**Addendum No. 1**

RE: Contract ID C203531  
WBS # 10CR.10901.37, Etc.  
State Funded

**Union County**

2 Section of NC-207, 1 Section of NC-601 &  
10 Sections of Secondary Roads

STATE	PROJECT NO.	SHEET NO.	TOTAL SHEETS
N.C.	10CR.10901.37 - 10CR.10901.39 10CR.20901.94 - 10CR.20901.109	7A	
F.A. PROJECT NO.

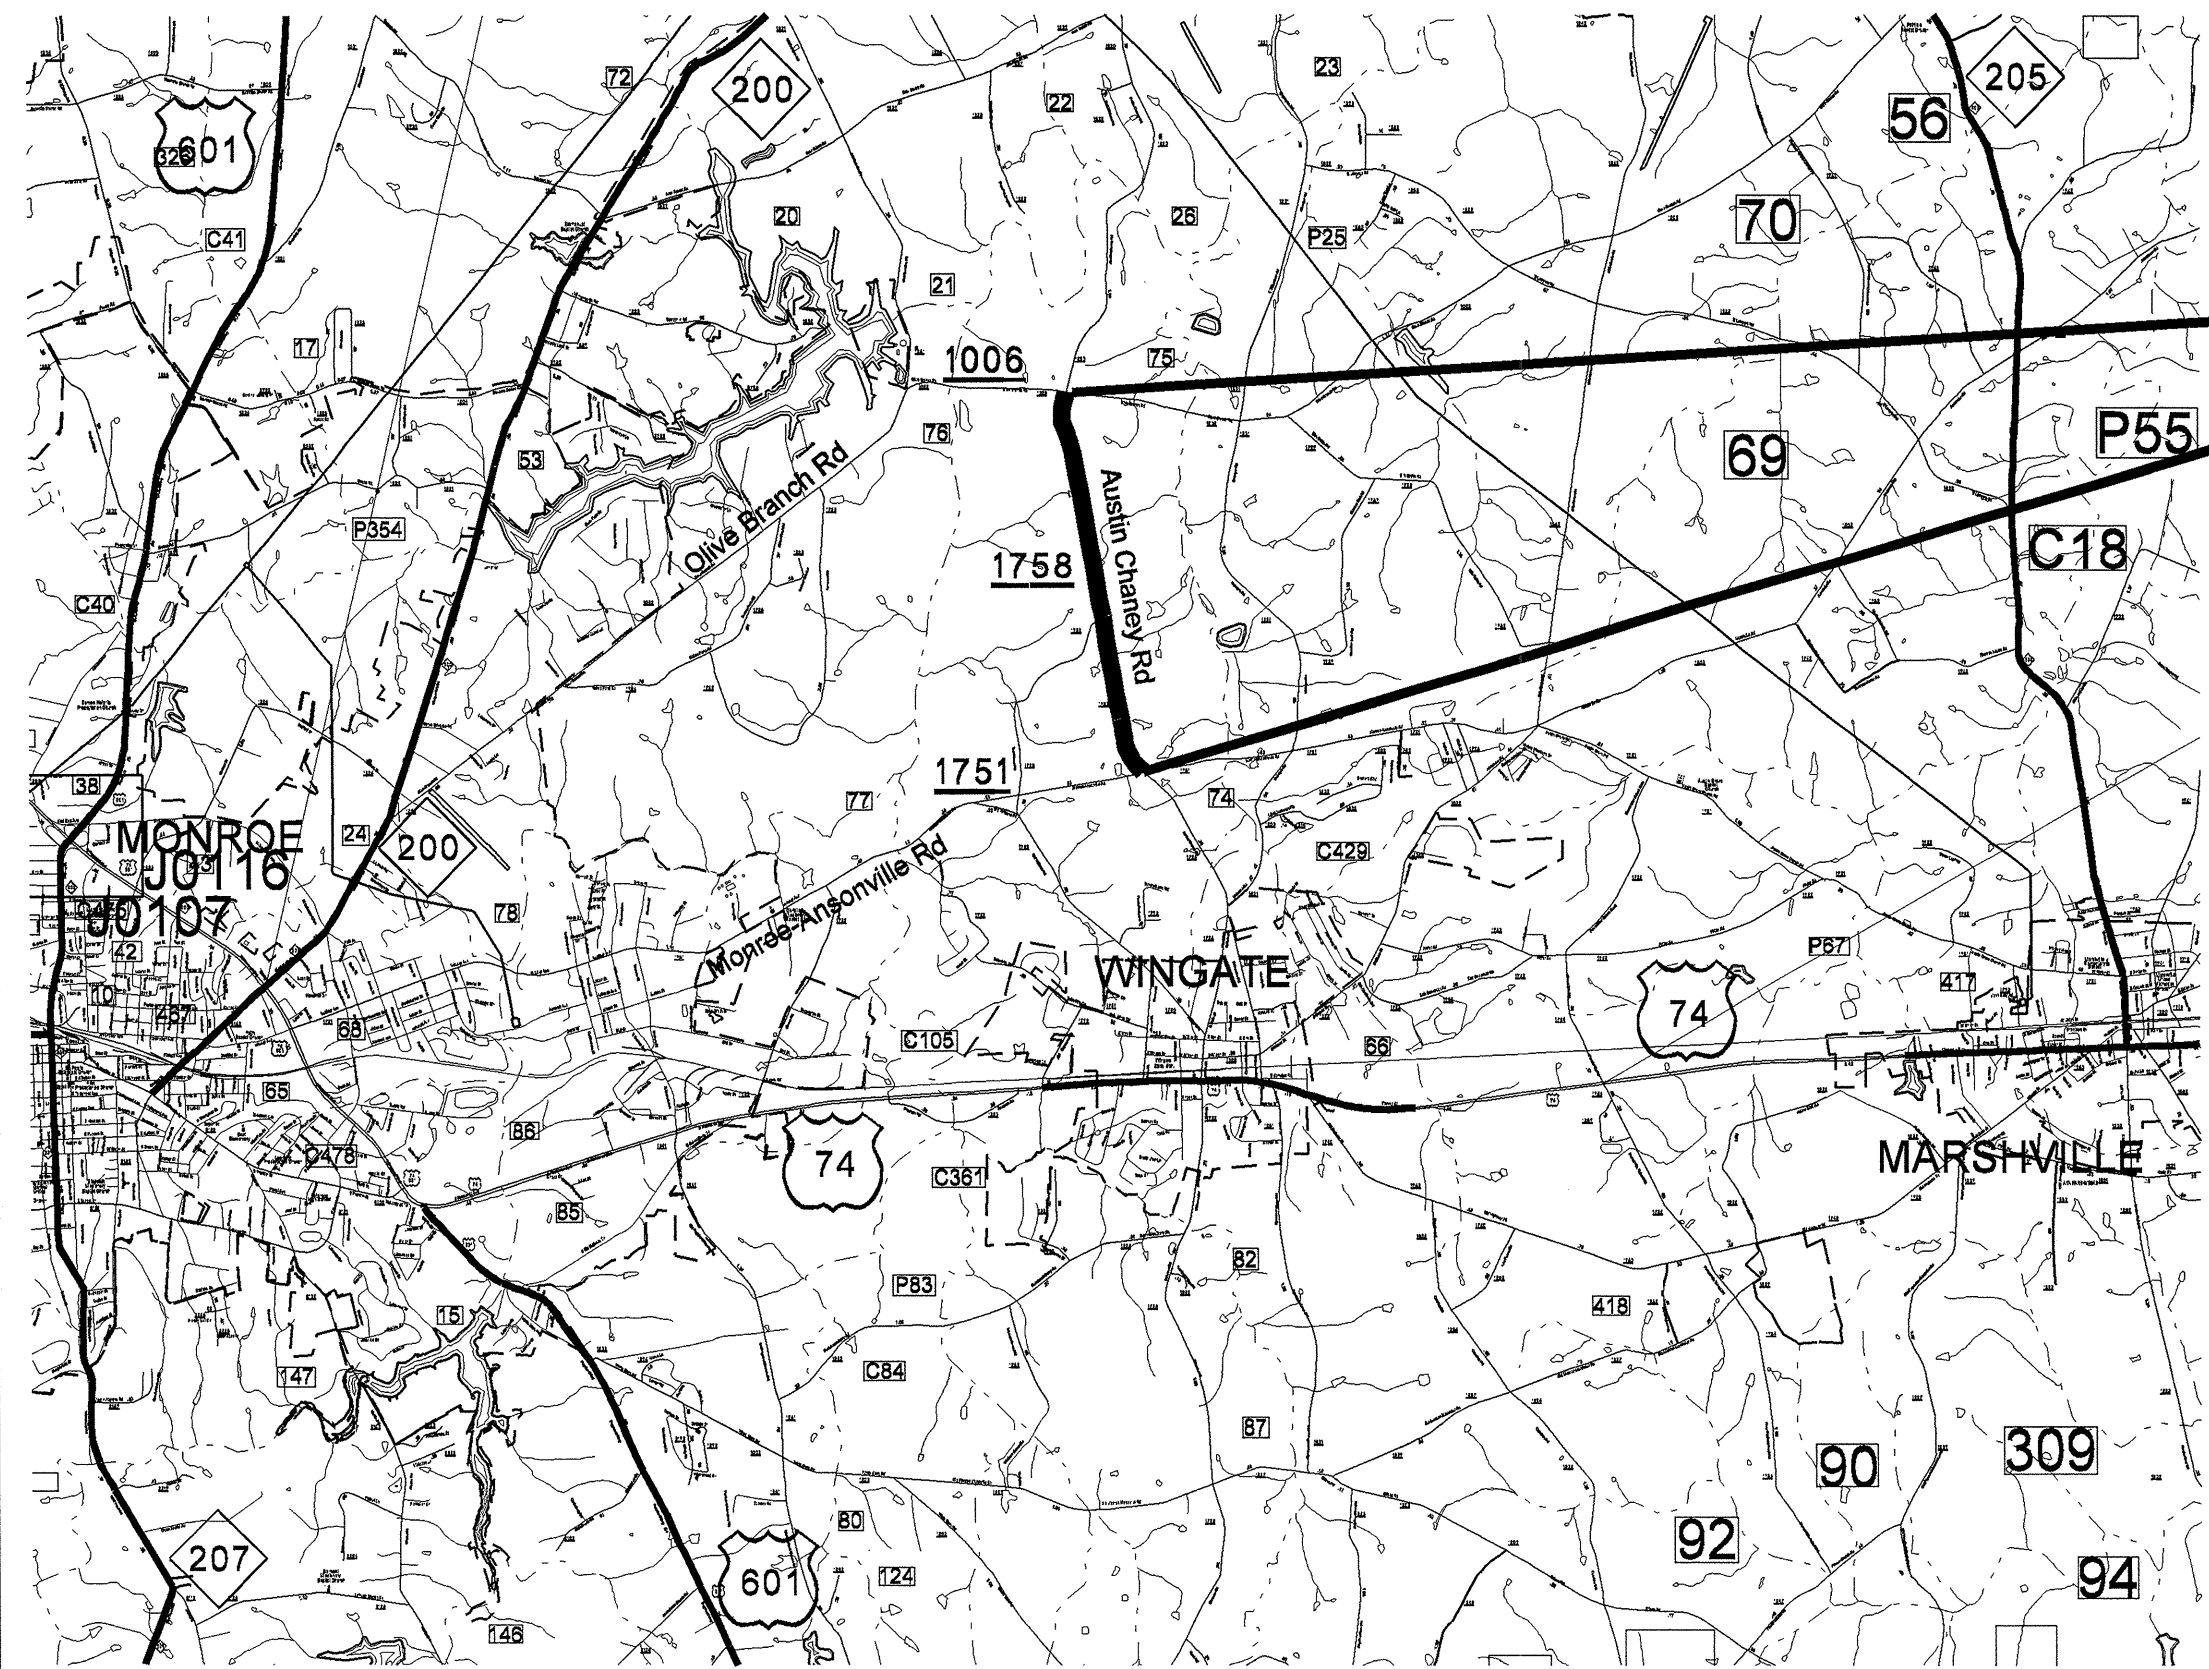
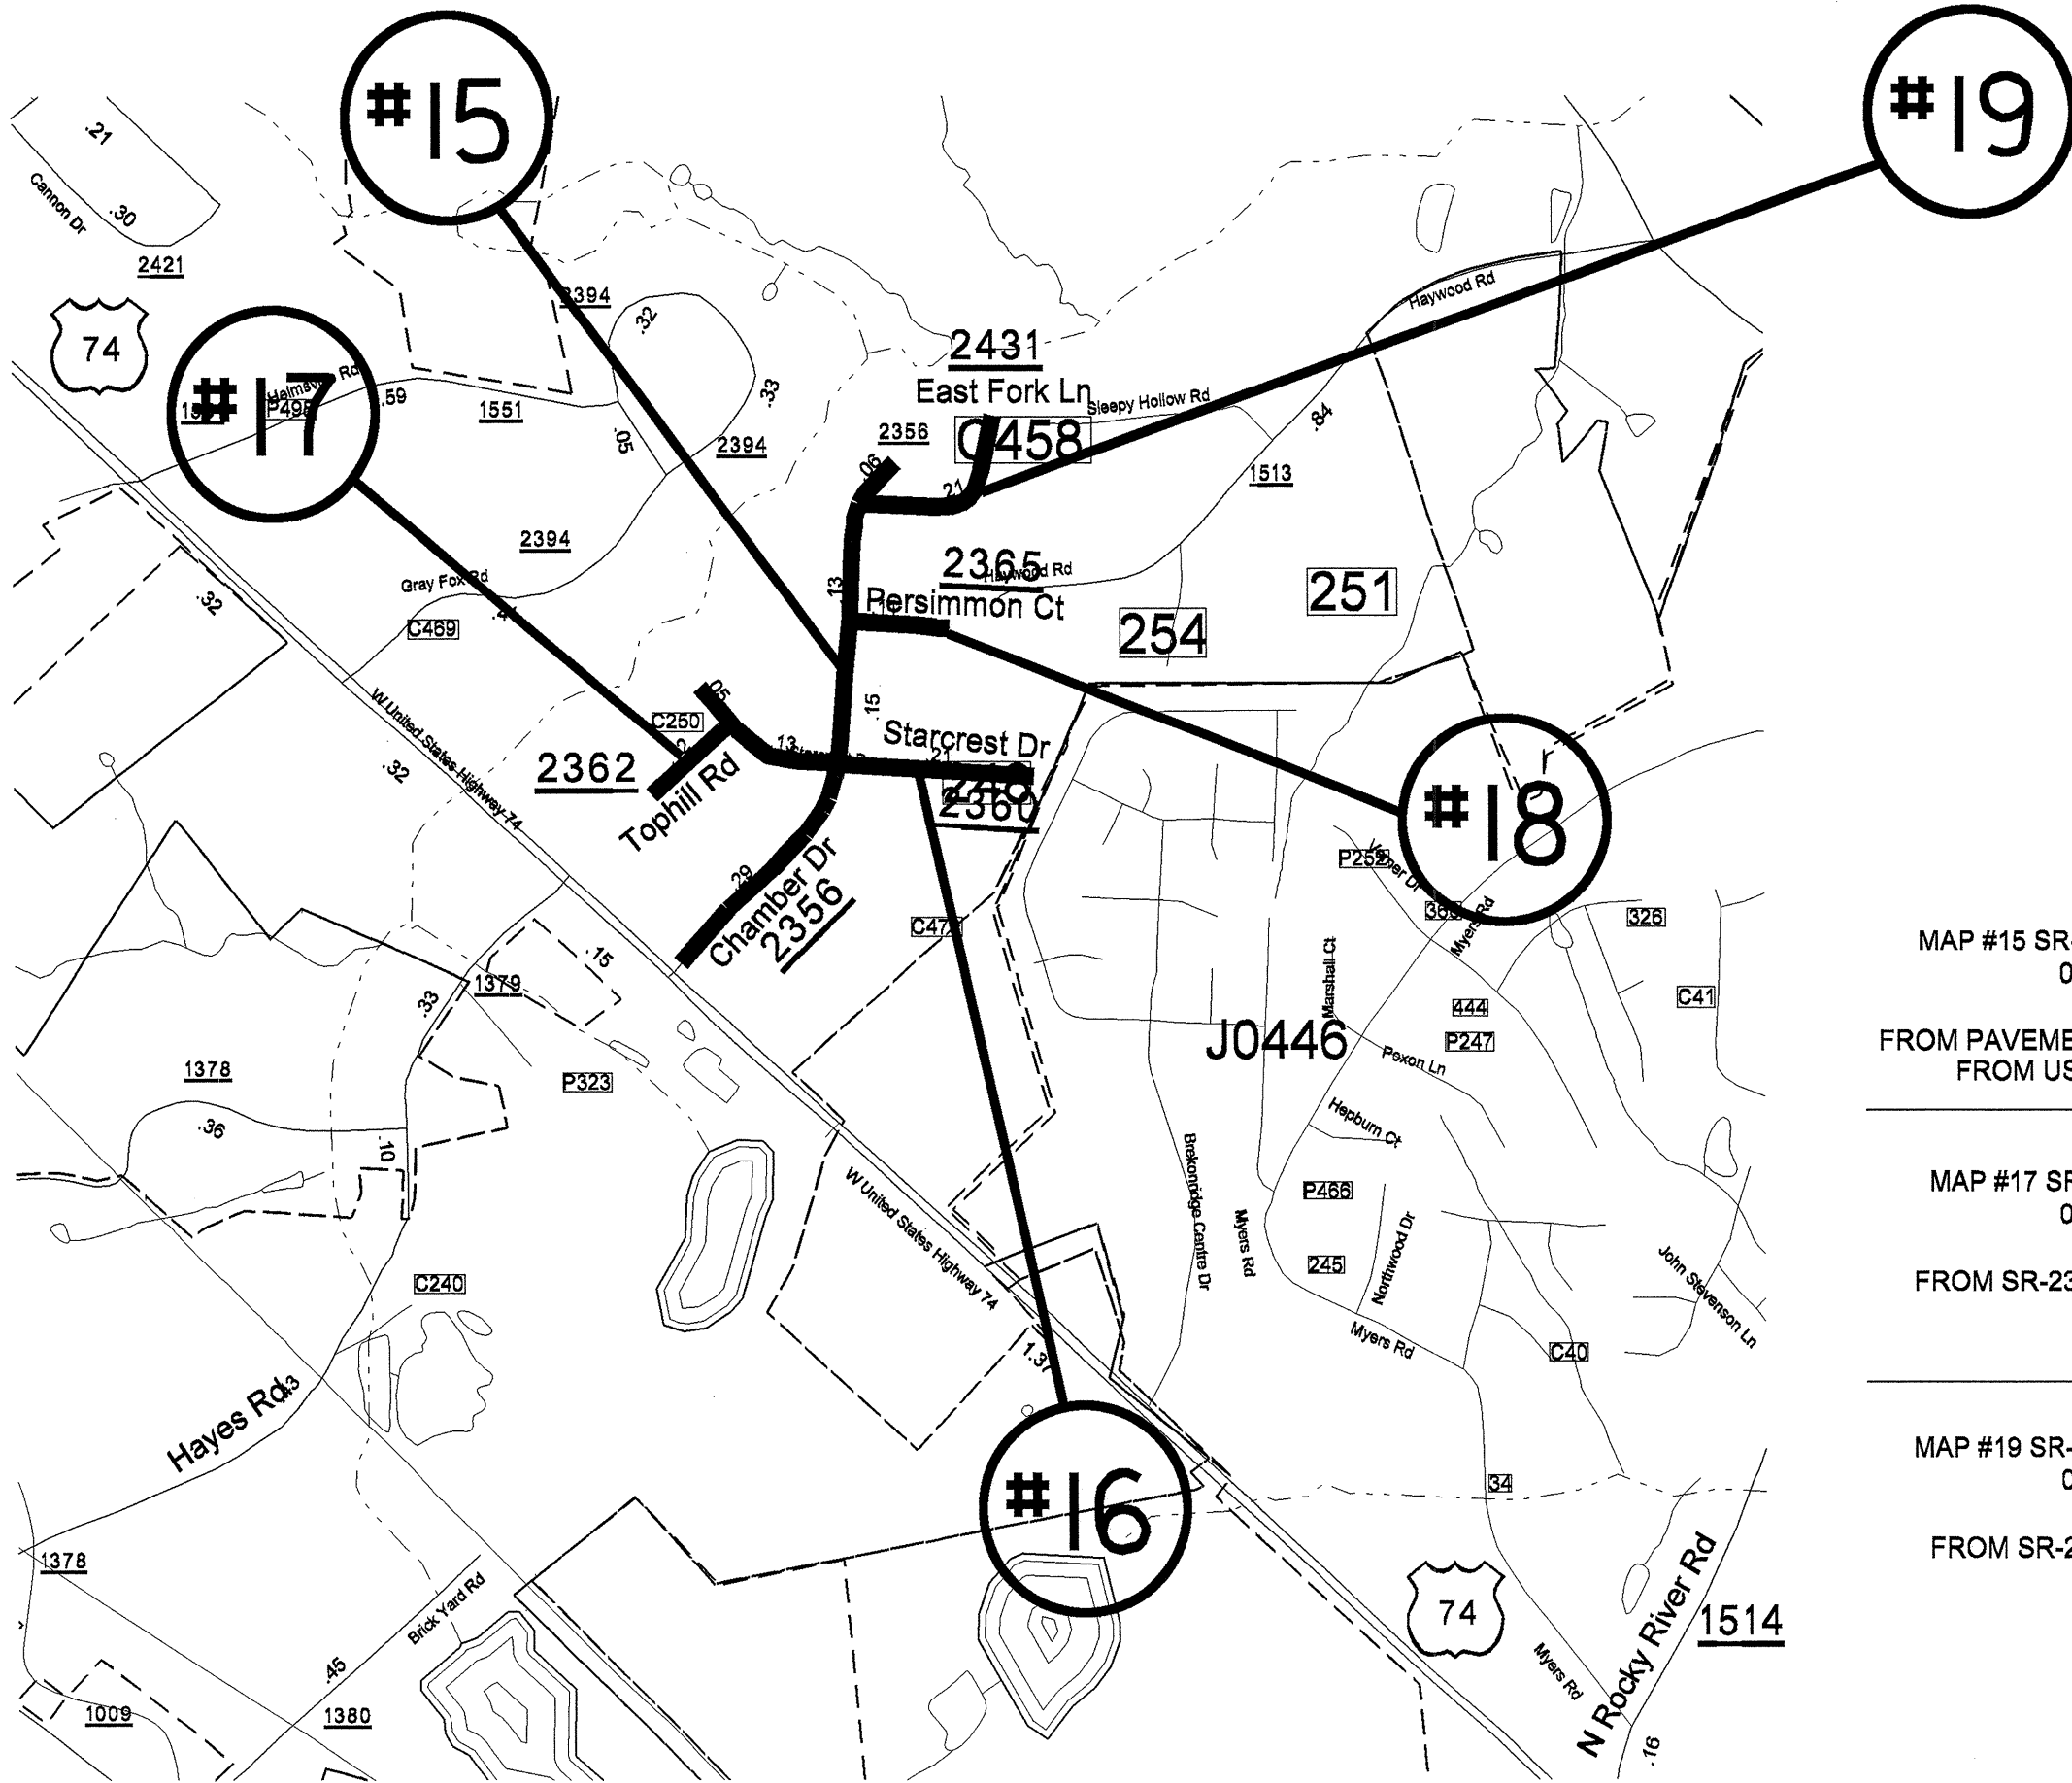
On New Sheet Nos. 7A and 7B, new Map Nos. 14 thru 19 have been added. Please staple New Sheet Nos. 7A and 7B after Sheet No. 7 in your plans.

STATE	PROJECT NO.	SHEET NO.	TOTAL SHEETS
N.C.	10CR099037 - 10CR099039 10CR099034 - 10CR099040	8	
F.A. PROJECT NO.

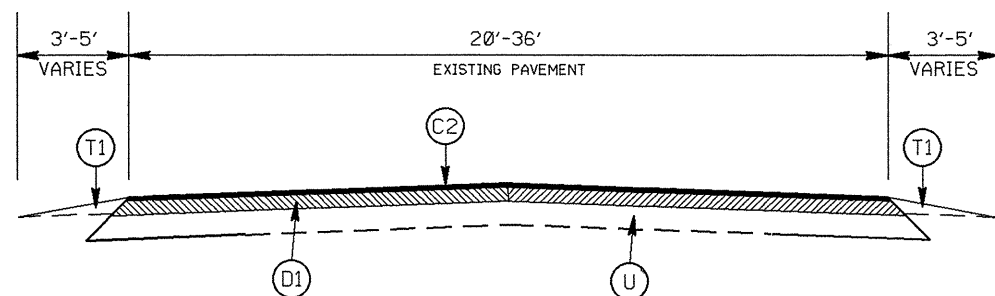
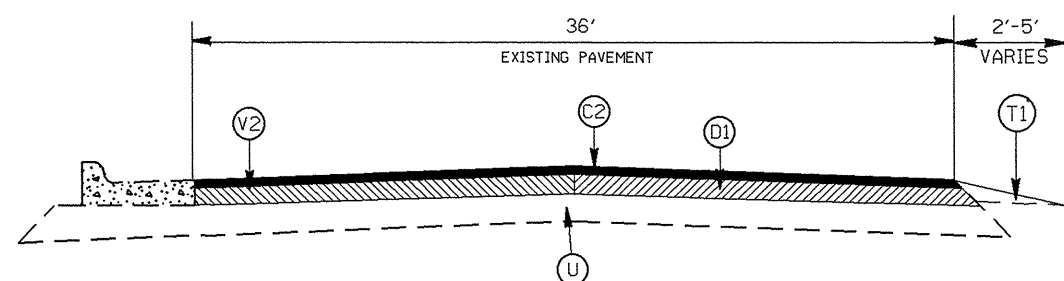
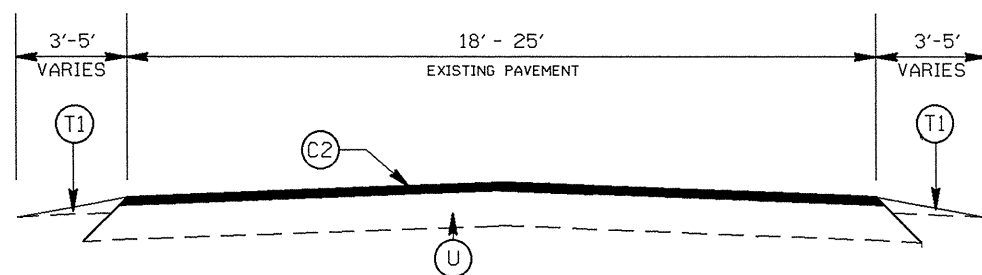
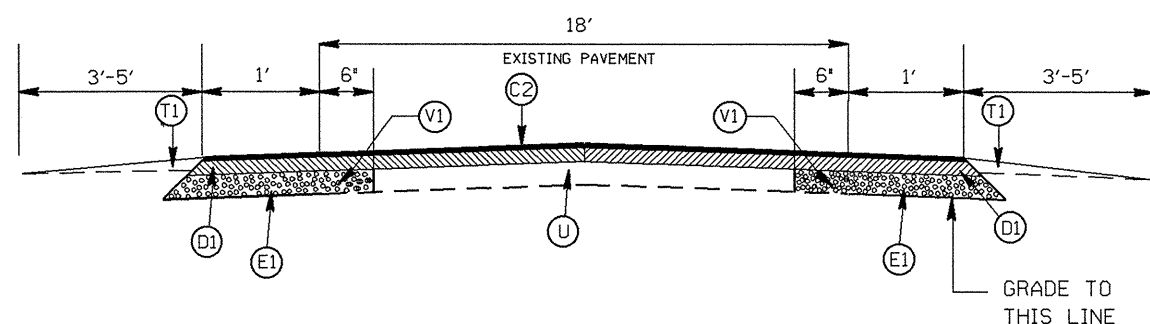
On Sheet No. 8, Typical Section No. 3 was revised to show additional maps that apply to that typical. Please void Sheet No. 8 in your sketch maps and staple the revised Sheet No. 8 thereto.

STATE	PROJECT NO.	SHEET NO.	TOTAL SHEETS
N.C.	DCR10903.37 - 10CR10903.38 DCR10903.34 - 10CR10903.09	9	
F.A. PROJECT NO.

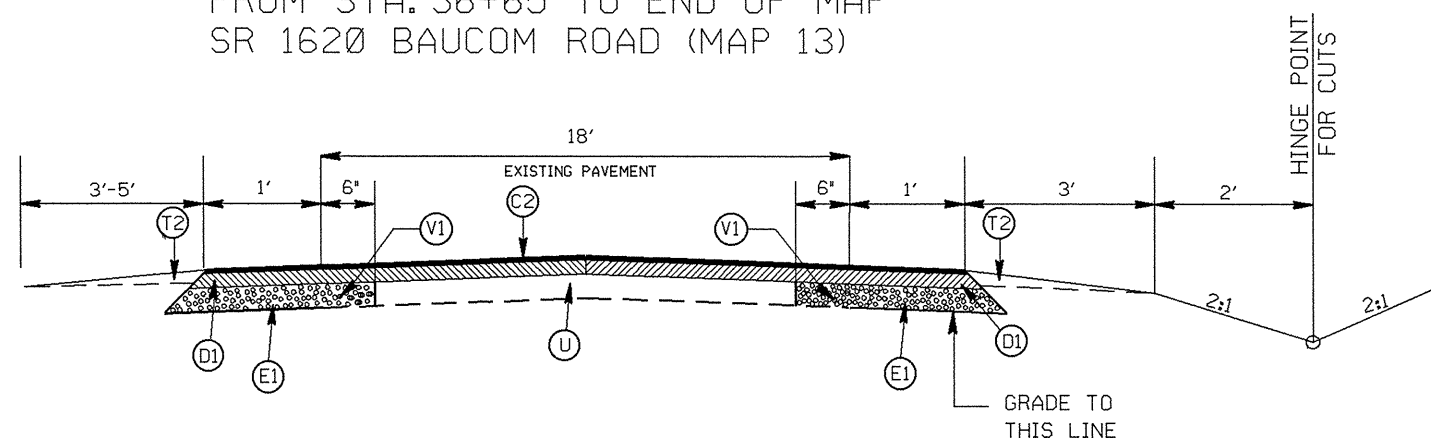
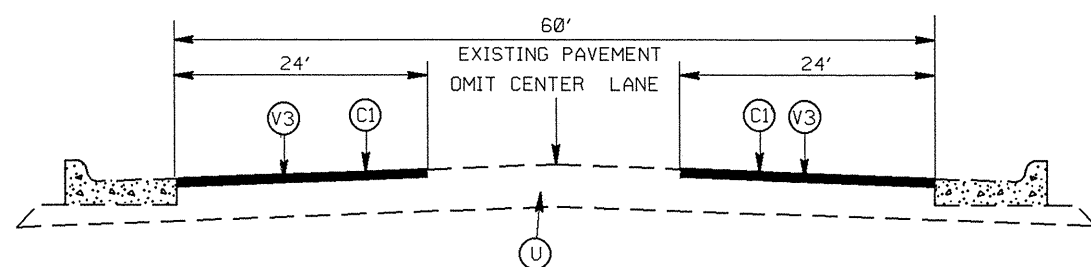
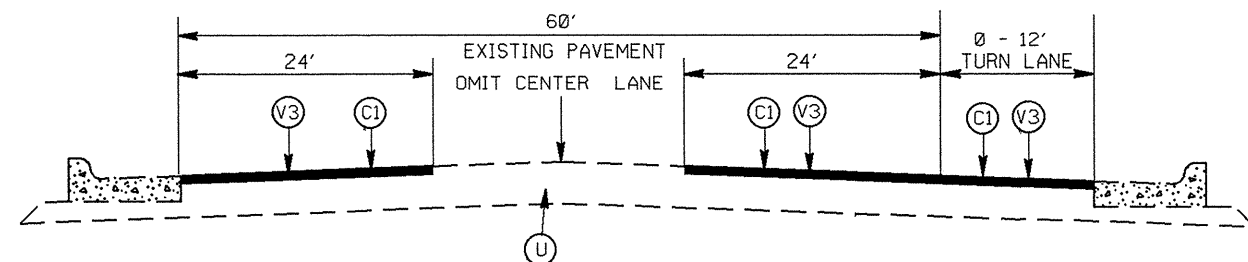
On Sheet Nos. 9 and 10 the "Pavement Schedule" was revised to add C3. Please void Sheet Nos. 9 and 10 in your sketch maps and staple the revised Sheet Nos. 9 and 10 thereto.

STATE	PROJECT NO.	SHEET NO.	TOTAL SHEETS
N.C.	SCP-2000.37 - 00R-2000.38 RCP-2000.54 - 00R-2000.68	IOA	
F.A. PROJECT NO.

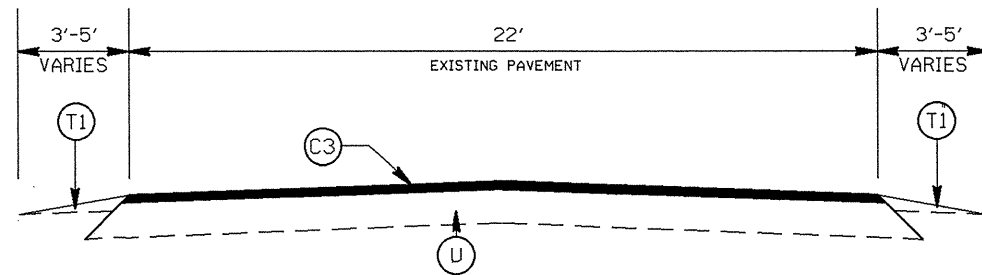
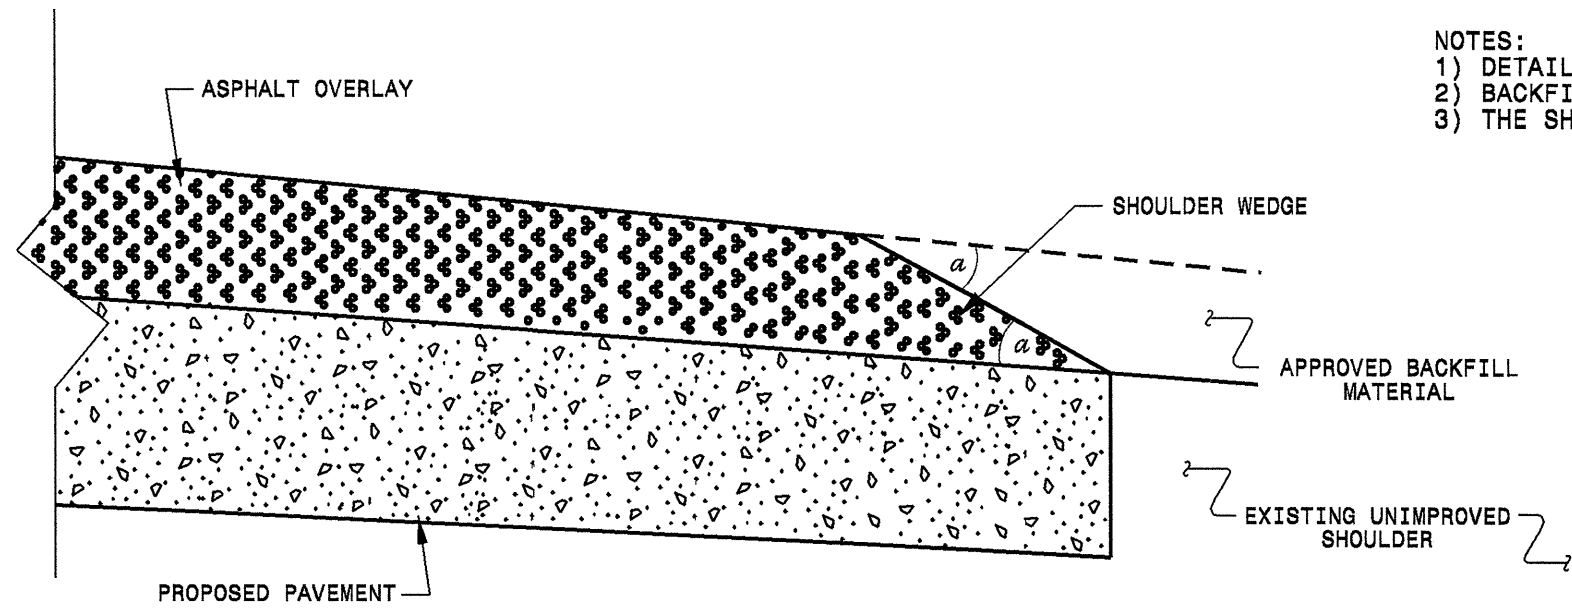
New Sheet No. 10A has been added to include new typical sections. Please staple New Sheet No. 10A after revised Sheet No. 10 in your sketch maps.
